Application number: 2025/91983	
What is the application for?:	Installation of replacement shop front (within a Conservation Area)
Address of the site or building:	40, Peel Street, Marsden, Huddersfield, HD7 6BW
Postcode:	HD7 6BW

PROPOSED ELEVATION SKETCH

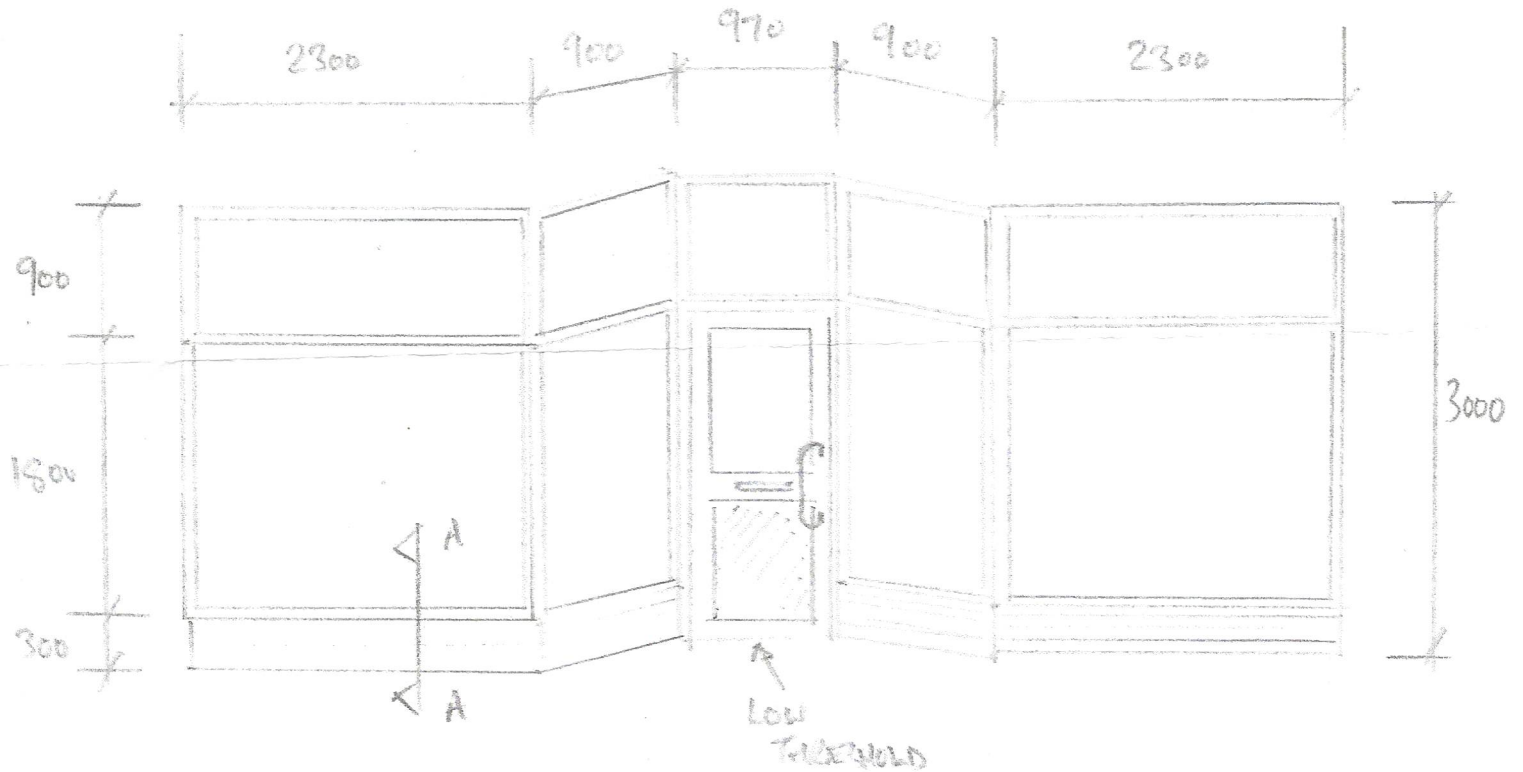
Type of comment: A general comment	
Do you wish your comments to be published on the website anonymously?	Yes
<p>I fully support the enhancement of shopfronts on Peel Street and support in principle works that seek to improve the condition of shopfronts, reduce carbon emissions and energy use, and which retain local distinctiveness and heritage value. However, I feel that the information submitted does not provide enough detail on the latter. Firstly, the existing shopfront has ornate carved mullions at present, which significantly add to the aesthetic and interest in the shopfront. It is not clear whether these will be replaced with something similar, or whether the entire replacement shopfront will have a simple square profile. The sketch of the proposed shopfront does not provide enough detail to fully understand what is being proposed, and how this compares to the existing profile, cross section and design of the existing shopfront. Further, the heritage statement does not make any reference to the heritage significance of the shopfront nor its contribution to the Conservation Area, and nor does it assess the impact of the proposed replacement. It does not seem to have been produced by a heritage professional. It does state that the shopfront is the oldest in the Colne Valley but if that is the case, its loss seems to have been easily proposed. The application does also not consider, in the view of a heritage professional, whether the shopfront can be repaired. I hope that the Council will therefore request further information, that is proportionate to the proposal, and ensure that what is being proposed has been fully considered, prior to making a decision.</p>
